Responses to City Review Comments Dated October 25th, 2023
Cui Preliminary Short Plat
SUB22 – 009

Please refer to the attached Arborist list of detailed responses to the City's Arborist review comments dated October 25th, 2023.

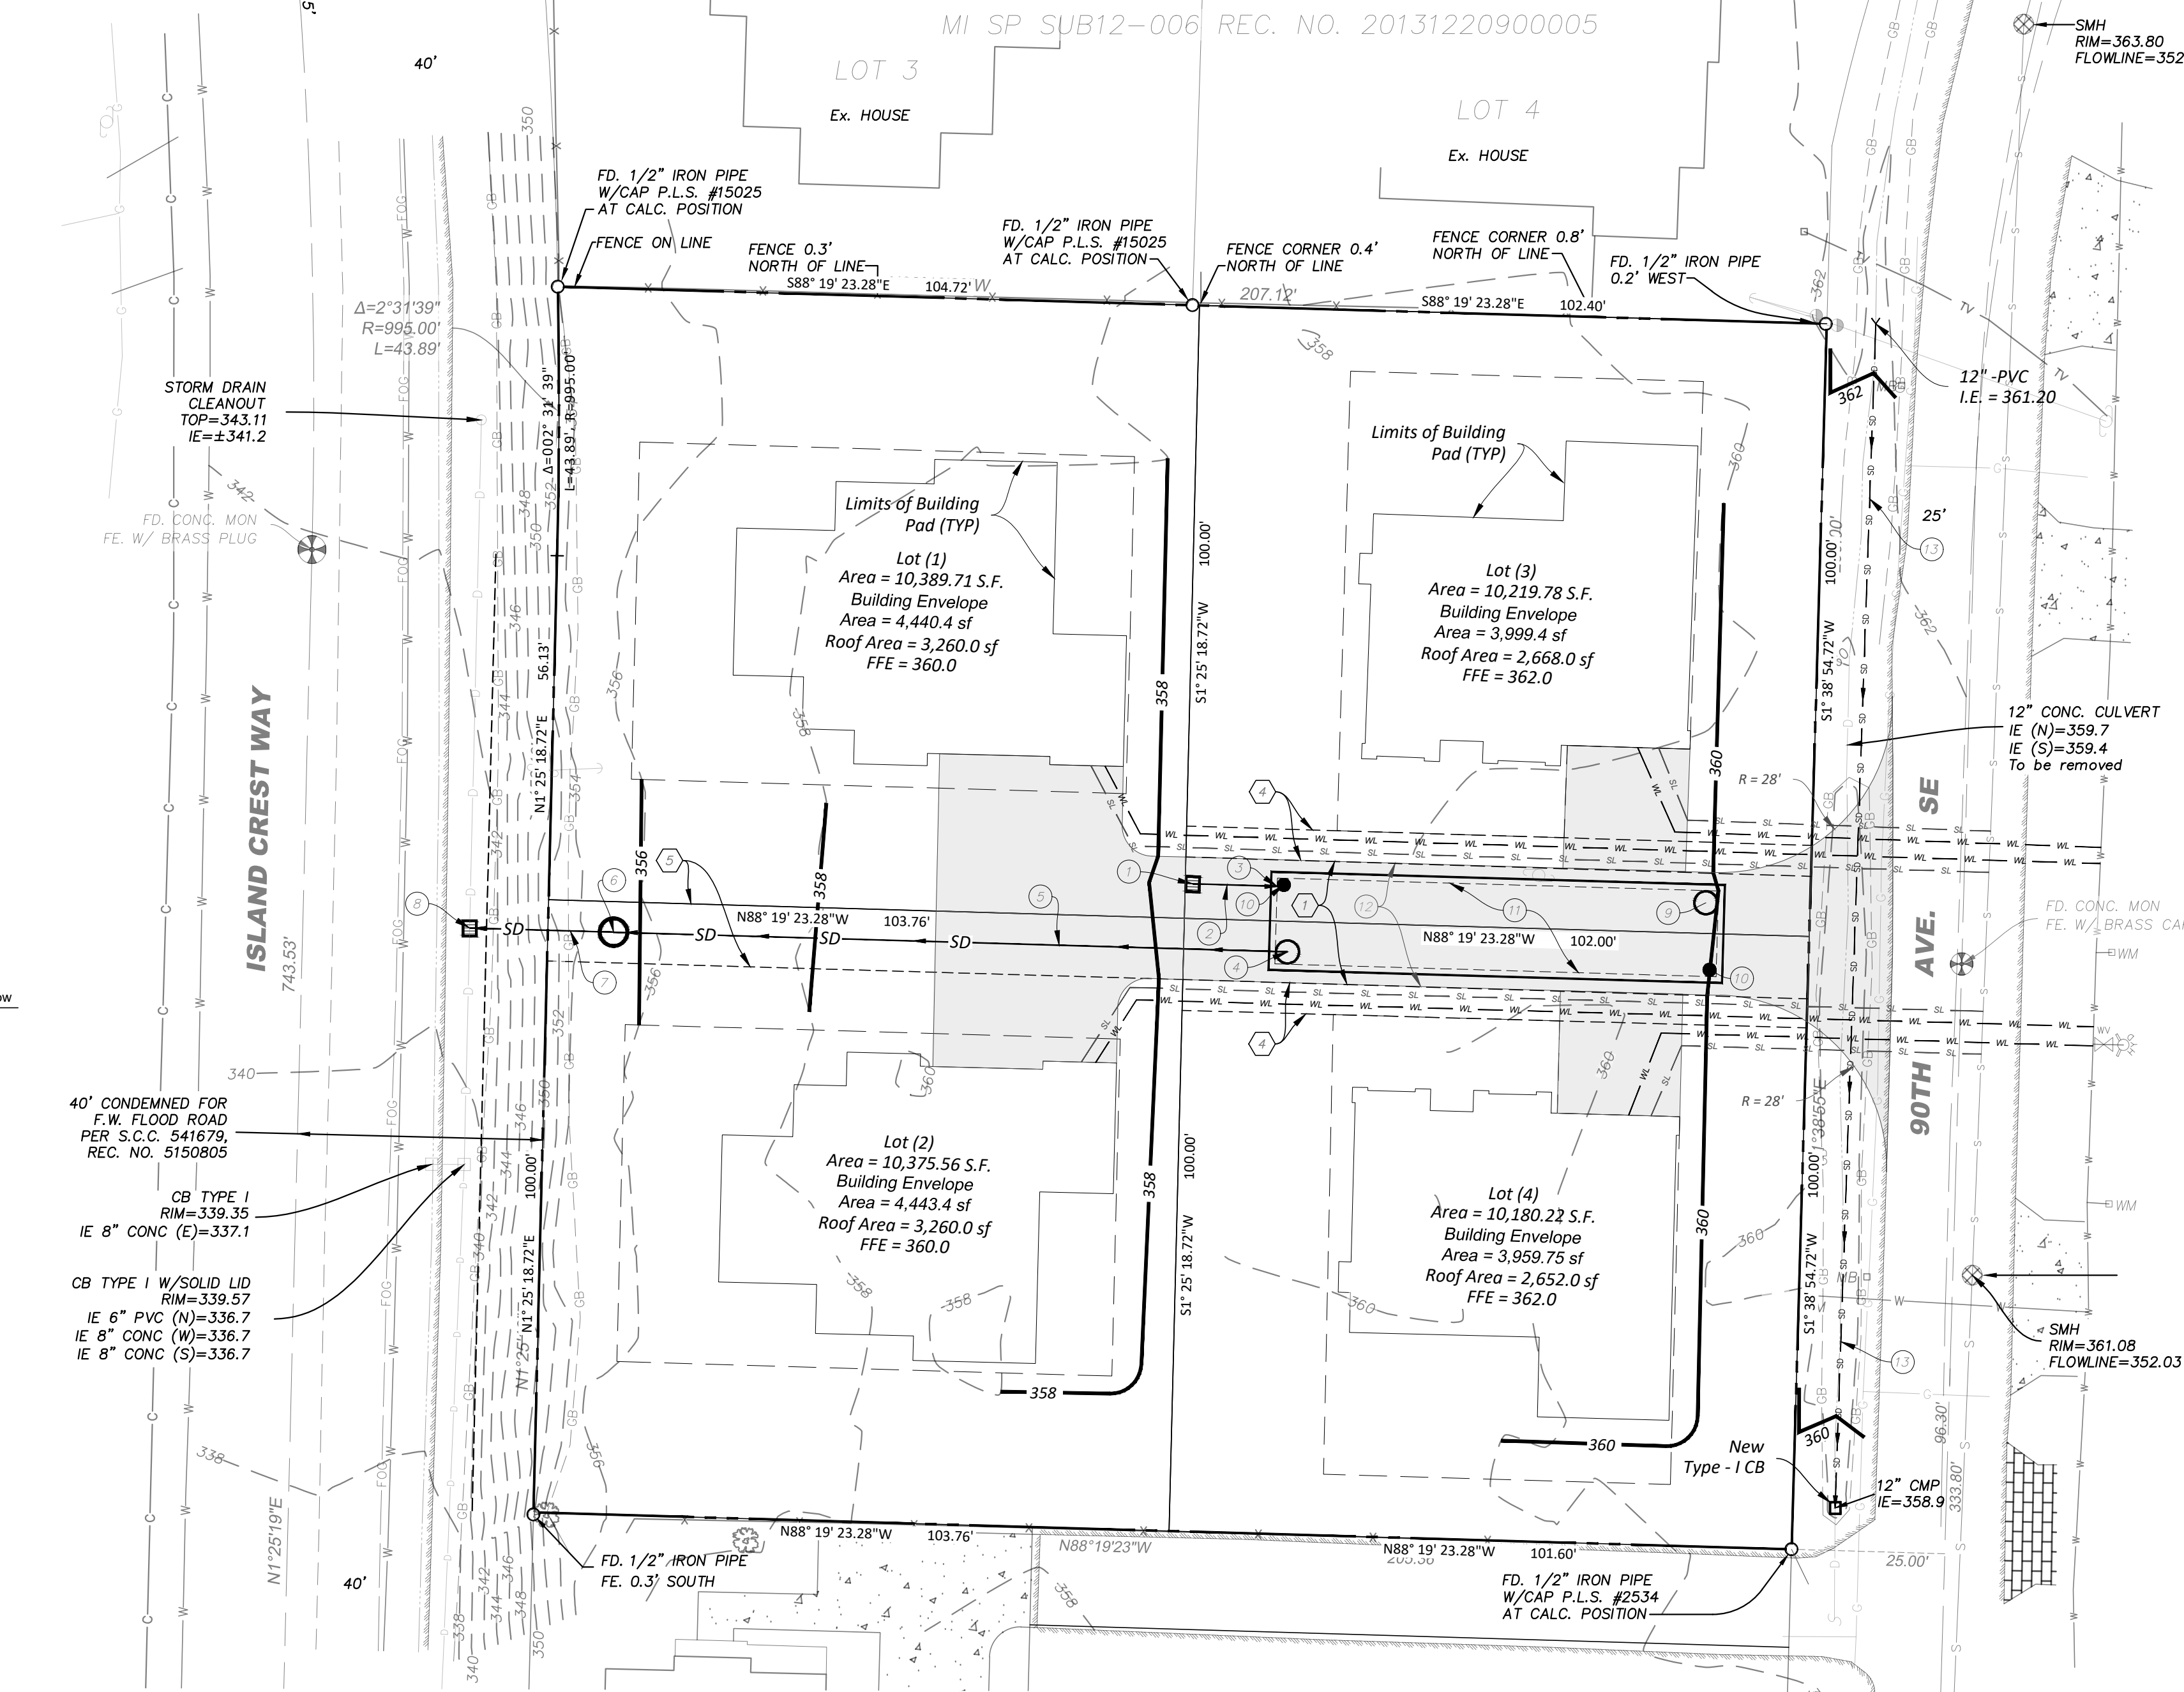
1. We moved the proposed building pad within proposed lot -1 westerly while maintaining compliance with required maximum gross floor area requirement. This action resulted in saving two exceptional trees, number 68 and 63 as shown on the attached revised Civil Plans and attached Trees Retention Plan.

2. We trimmed proposed building pad within proposed lot – 2 while maintaining compliance with required maximum gross floor area requirement. This action resulted in saving one exceptional tree number 54 as shown on the attached revised Civil Plans and Trees Retention Plan.

3. We trimmed proposed building pad within proposed lot – 3 while maintaining compliance with required maximum gross floor area requirement. This action resulted in saving two exceptional trees, number 4 and 5 as shown on the attached revised Civil Plans and Trees Retention Plan.

4. We modified the layout of proposed building pad within Lot – 4 by flipping the proposed house while maintaining compliance with required maximum gross floor area requirement. This action resulted in less impact to surrounding exceptional trees as shown on the attached revised Civil Plans and Trees Retention Plan.

The above reconfiguration to proposed building pads will result in saving 8 exceptional trees out of existing 12 exceptional trees. It is not possible to save the remaining 4 exception trees due to the need of proposed on-site access road, proposed on-site drainage retention/detention vault, proposed on-site storm water conveyance system, and proposed on-site utilities.
